**From:** UrbanGrowth <UrbanGrowth@sydneywater.com.au>  
**Sent:** Tuesday, 6 December 2016 10:17 AM  
**To:** Thomas Piovesan  
**Subject:** RE: Referral - Oakdale South Industrial Estate - SSD 6917 MOD 1

**Categories:** Submission

SSD6917 - Oakdale South Industrial Estate, TL: Syd Sth - Syd West No.1 330kV (Fdr 30 Str 10-13 & Fdr 14 Str 110-111)	
Property of Transgrid. No warranty is given that information shown is complete or accurate.		PRODUCED FROM TAMIS	Scale: 1:15000
18/11/2015 15:14:49 Created by: P86665		A4

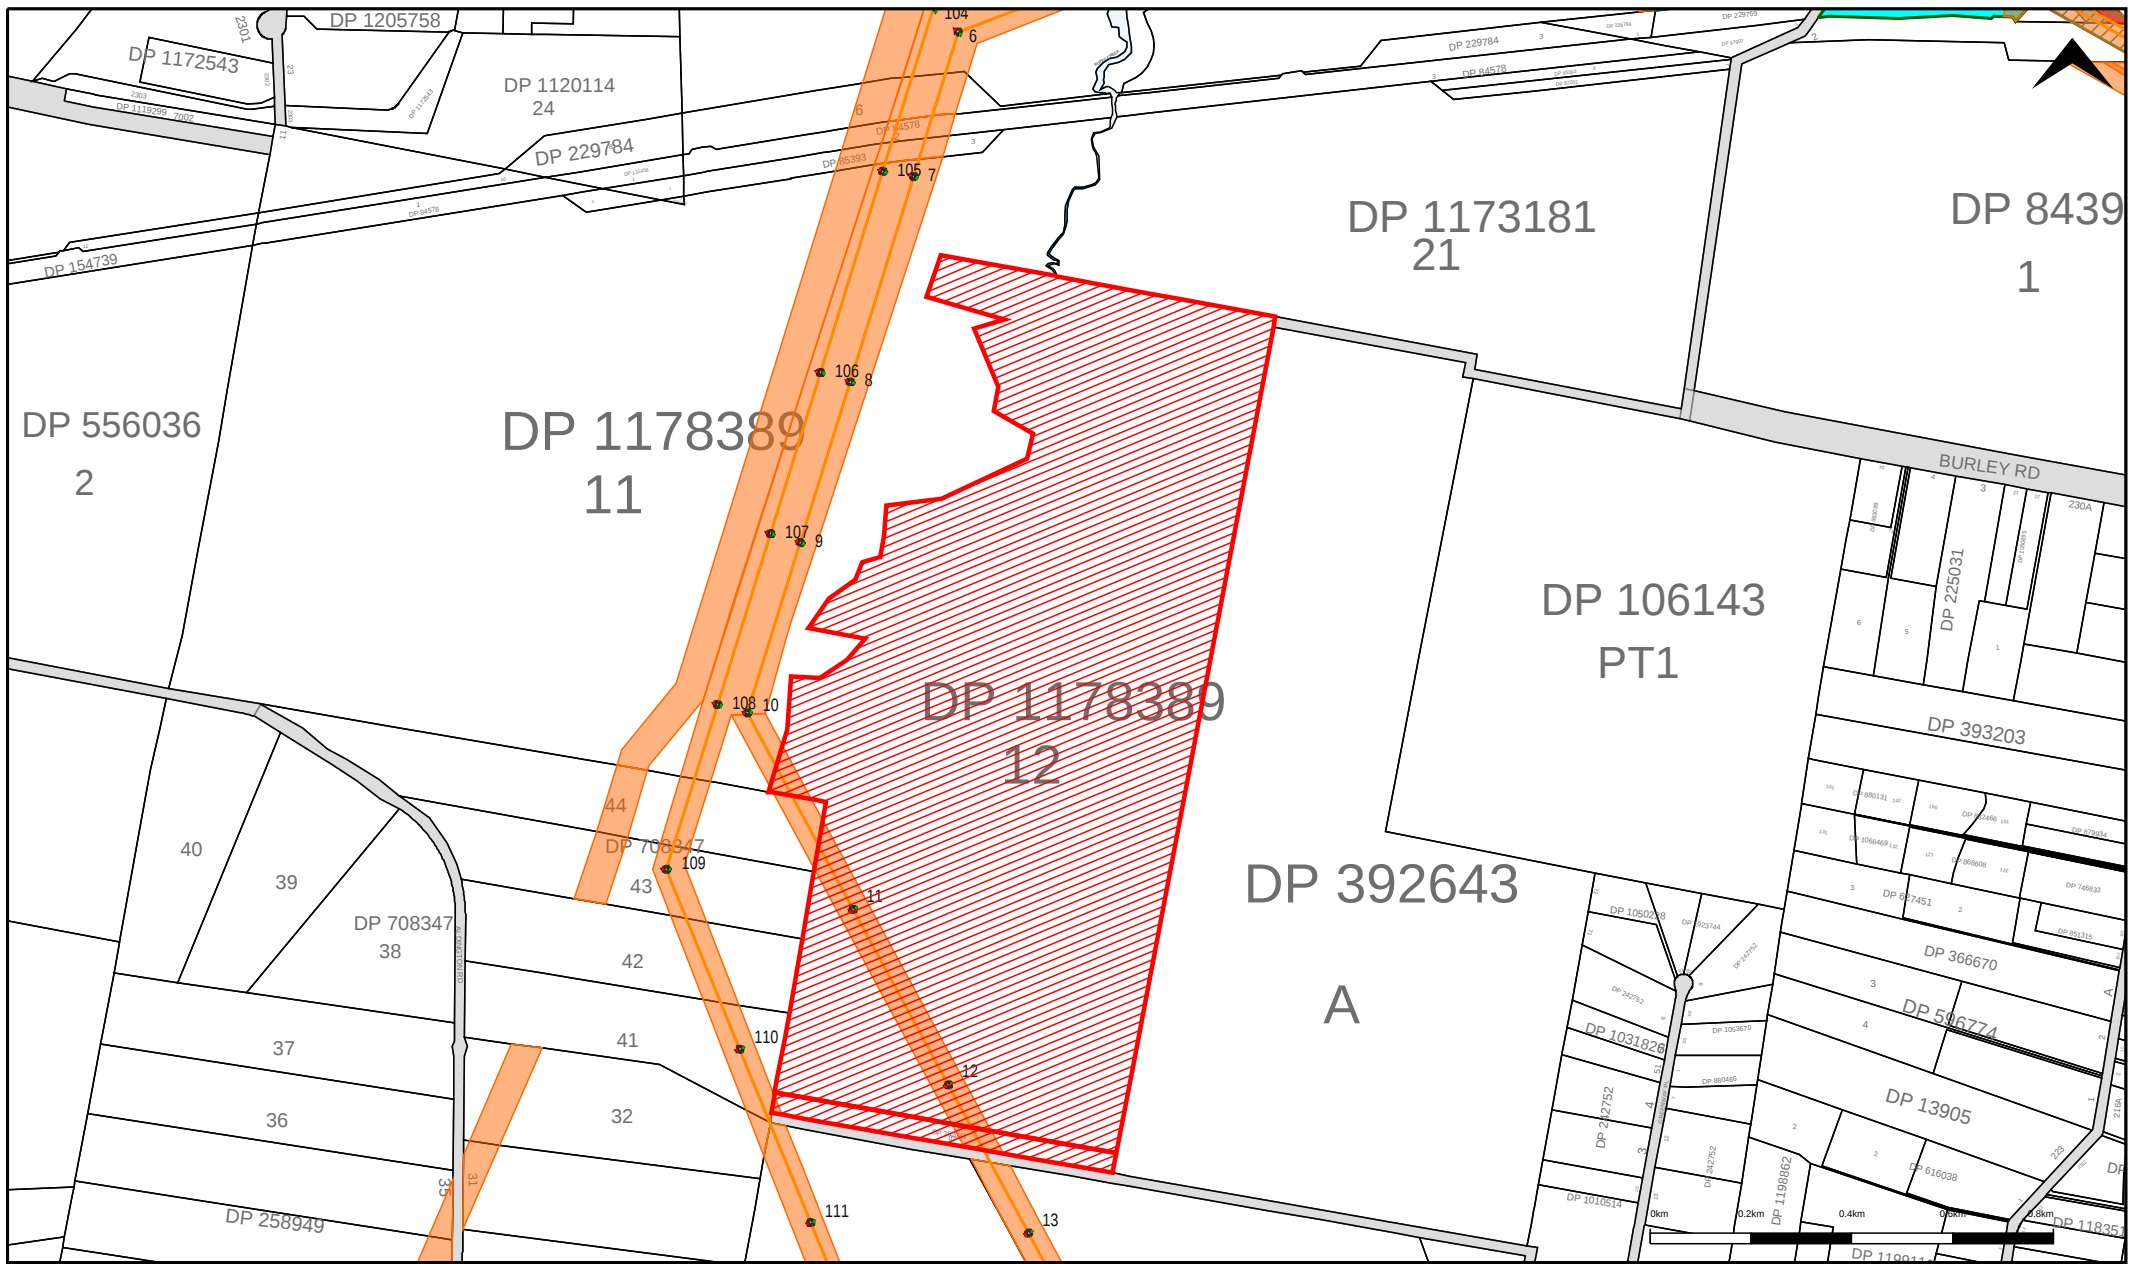
Thank you for notifying Sydney Water of the proposed development listed above. We have reviewed the proposal and can provide the following comments for your consideration.

Due to the proximity of the proposed development to Sydney Water assets, we recommend that Council imposing the following conditions of consent:

The approved plans must be submitted to the Sydney Water [Tap in™](#) online service to determine whether the development will affect any Sydney Water sewer or water main, stormwater drains and/or easement, and if further requirements need to be met.

A Section 73 Compliance Certificate under the *Sydney Water Act 1994* must be obtained from Sydney Water.
